OXFORDSHIRE COUNTY COUNCIL'S RESPONSE TO CONSULTATION ON THE FOLLOWING DEVELOPMENT PROPOSAL

Application no: 22/00747/OUT

Proposal: Outline planning application for the development of up to 370 homes, public open space (including play areas and woodland planting), sports pitches and pavilion, drainage and engineering works, with all matters reserved (appearance, landscaping, layout and scale) except for vehicular and emergency accesses to Bicester Road.

Transport Schedule

Access Strategy

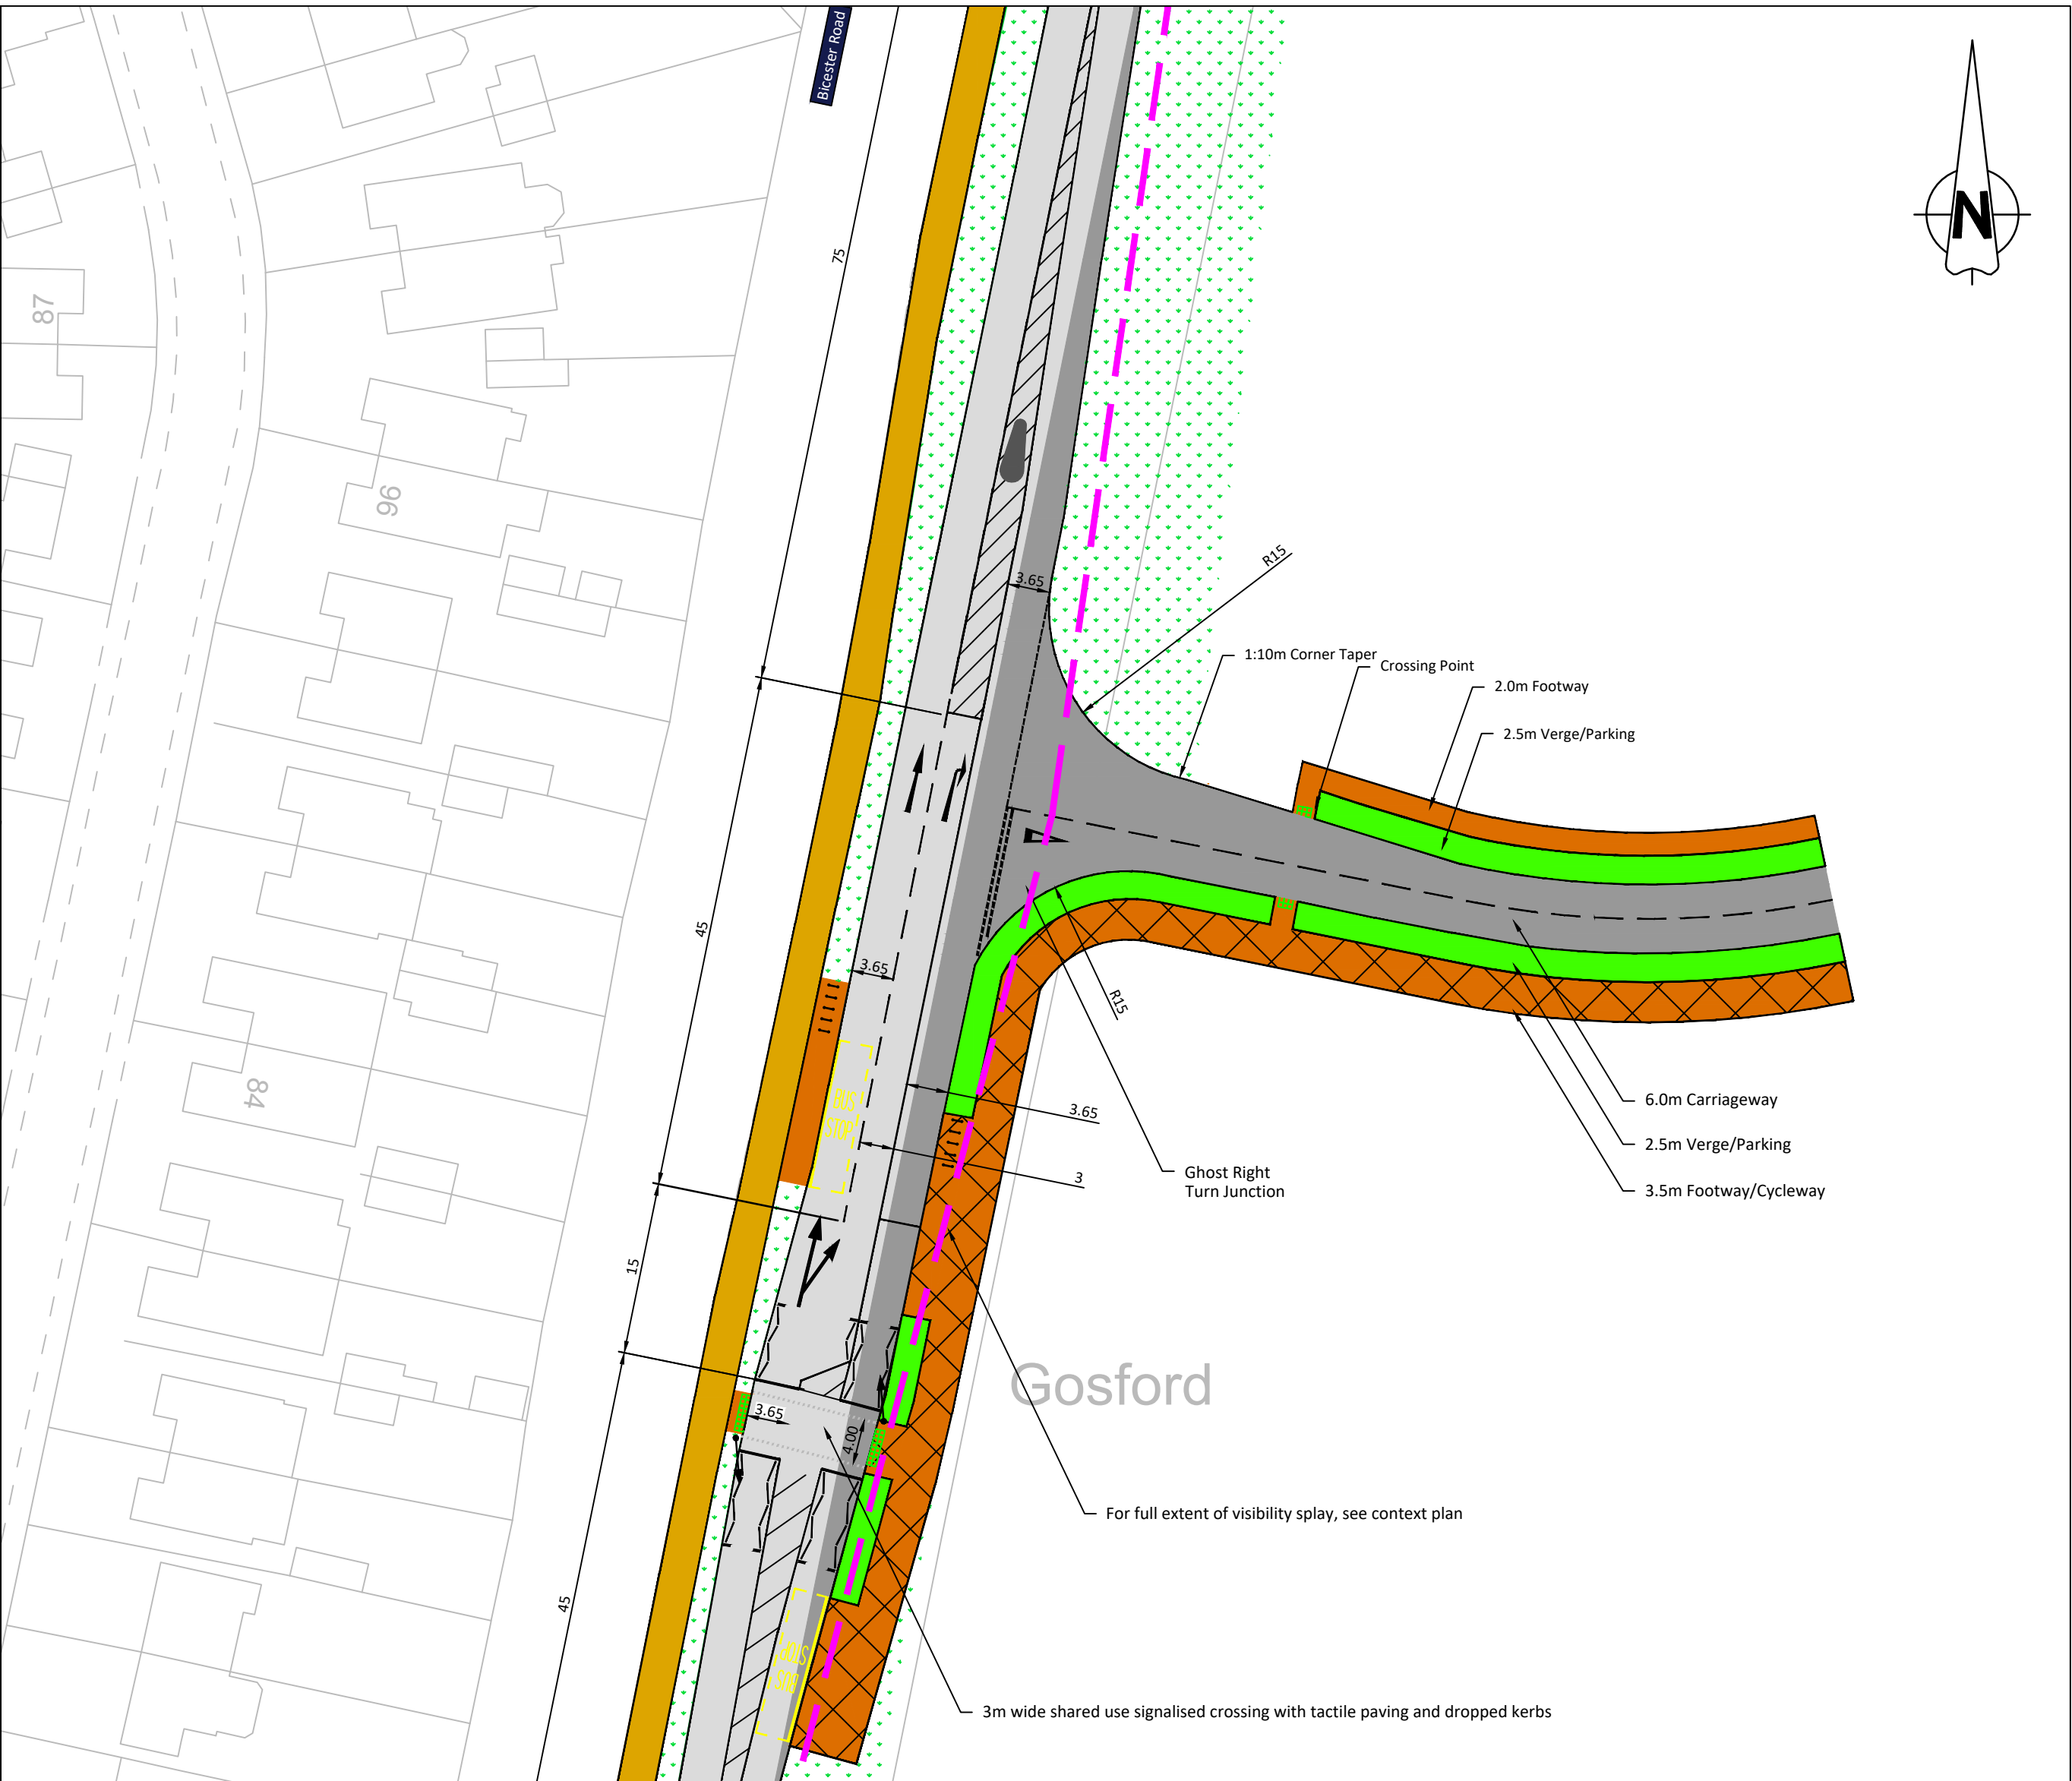
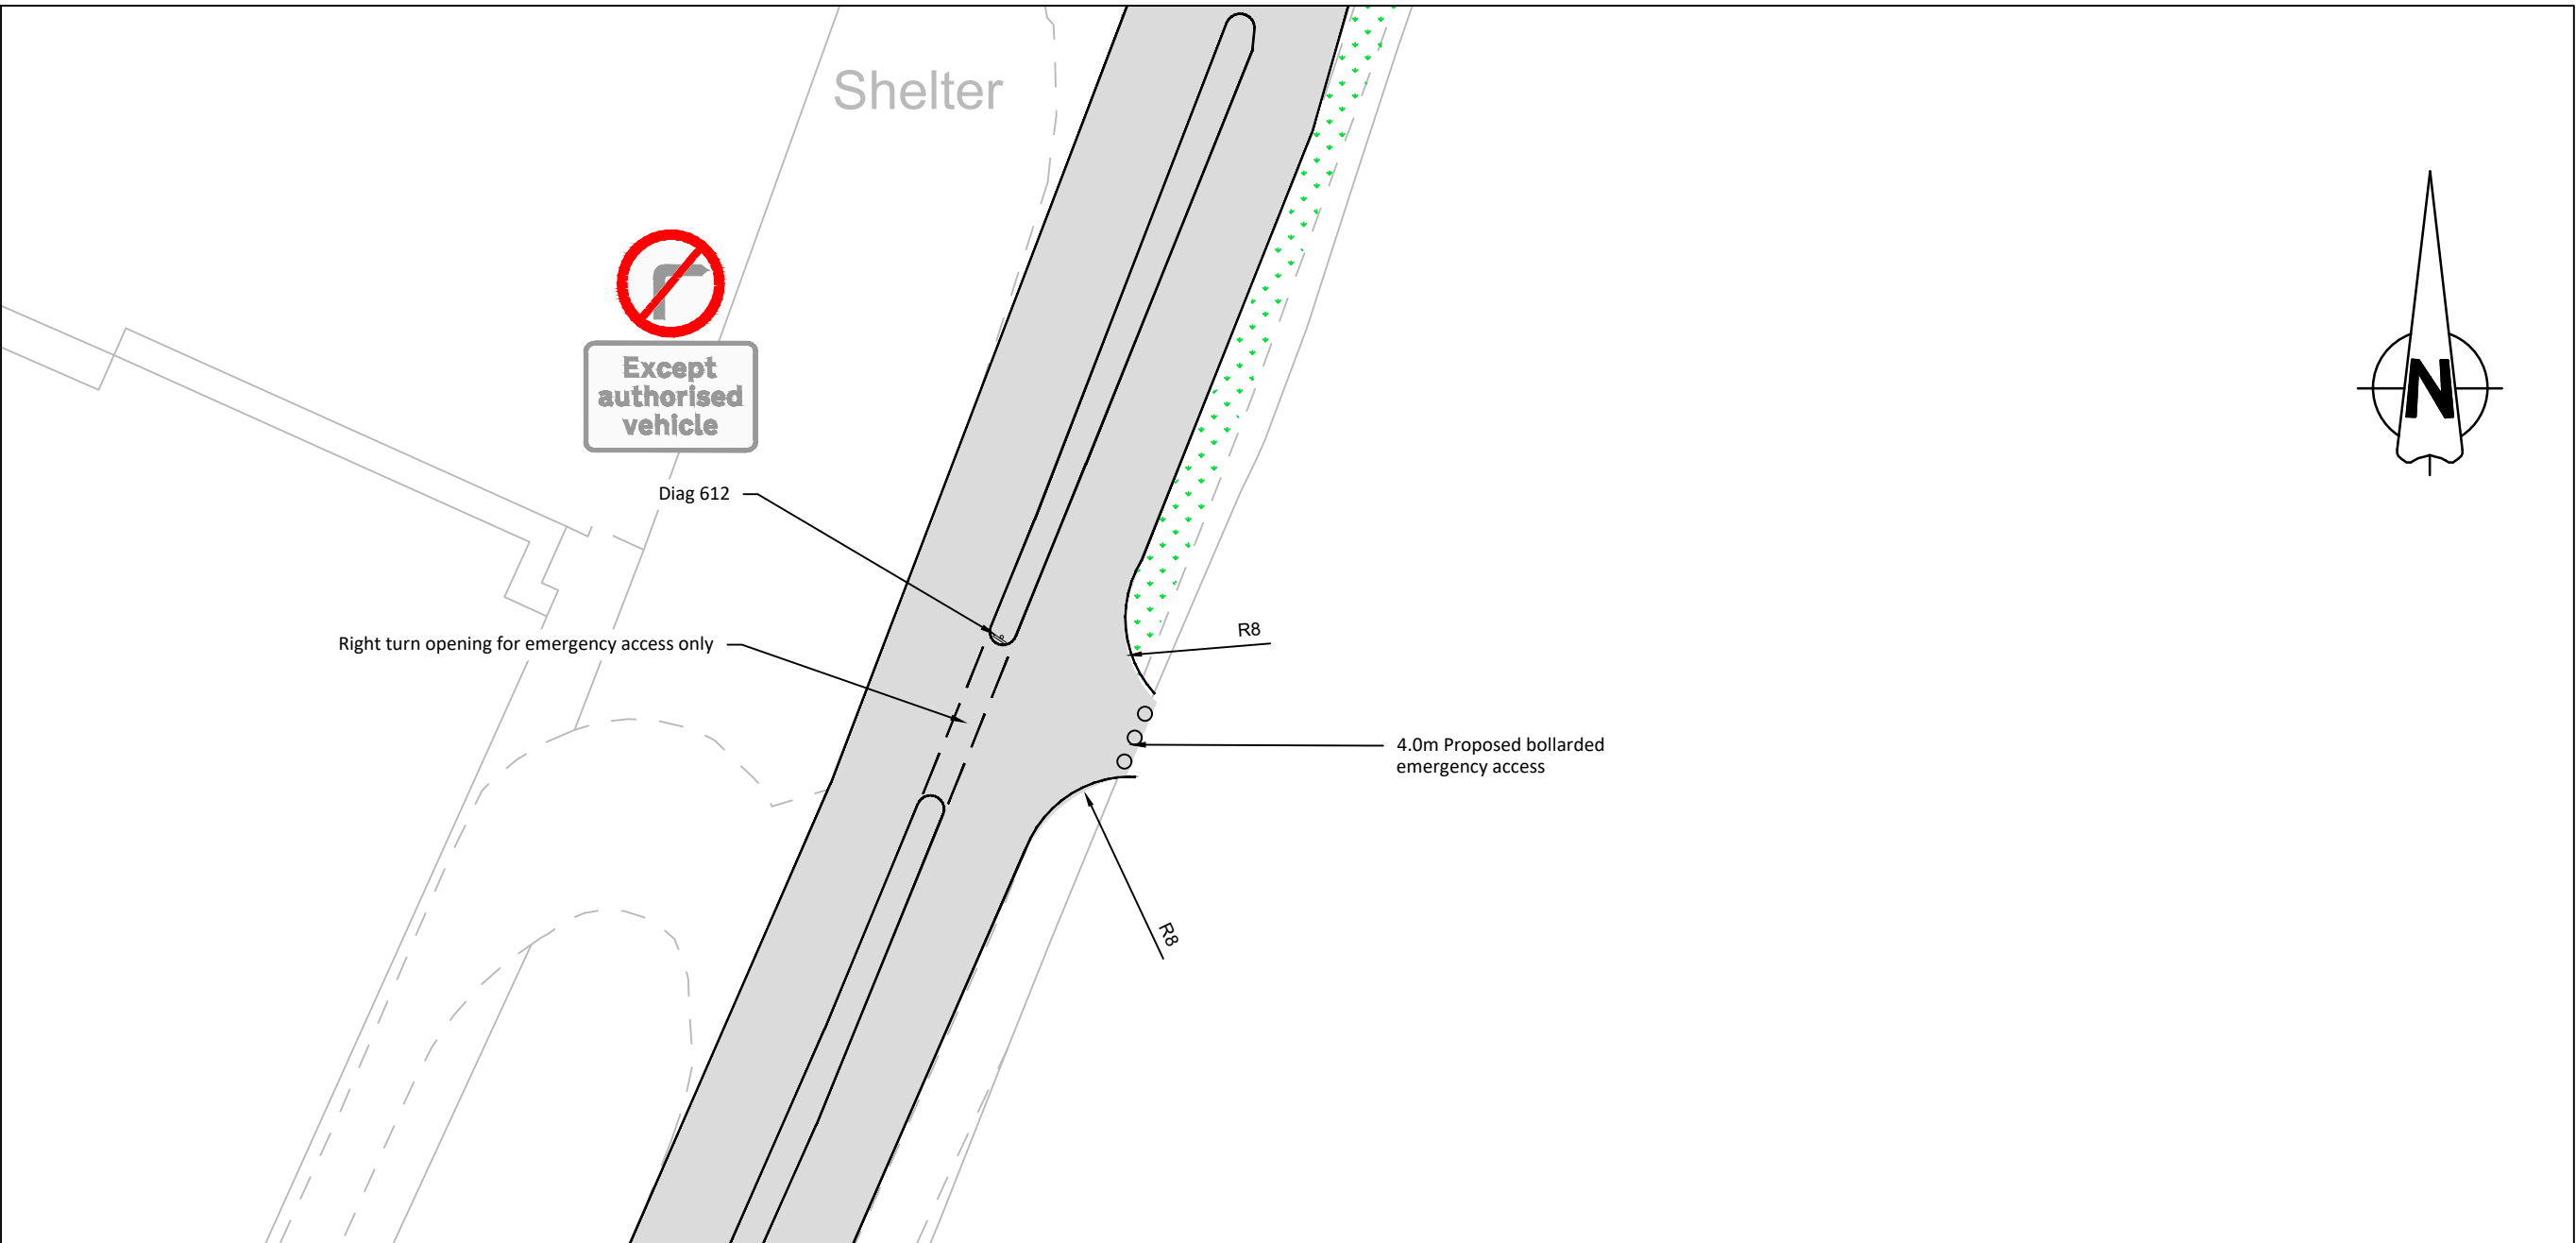
Para 3.5 acknowledges that the swept path drawing exercise was excluded in the previous submission. This has now been appended to the TN, reviewing which I note that the left-out manoeuvres cannot be safely completed in event of waiting right turning vehicles. To address this, it is suggested that the first 15m of the access need be widened to 5.5m. Alternatively, amendments to the access arrangement that take the form of a localized widening of the carriageway to ensure such vehicles can safely egress. **(Reason for objection)**

Para 3.6 implies that a Stage 1 RSA has been commissioned but yet to be submitted. Again, as stated in our previous response, it is at this stage that the RSA is required to ascertain that the access is without safety issues that need to be addressed. **(Reason for objection)**

It is agreed that the uncontrolled crossing on Bicester Road south of the proposed access junction shall now take the form of a signalized crossing. I note that the second proposed uncontrolled crossing shown to be about 50m north of the access junction shall also be upgraded to a signalized one. The secondary crossing may not require signalization where users are able to utilize stoppages in traffic.
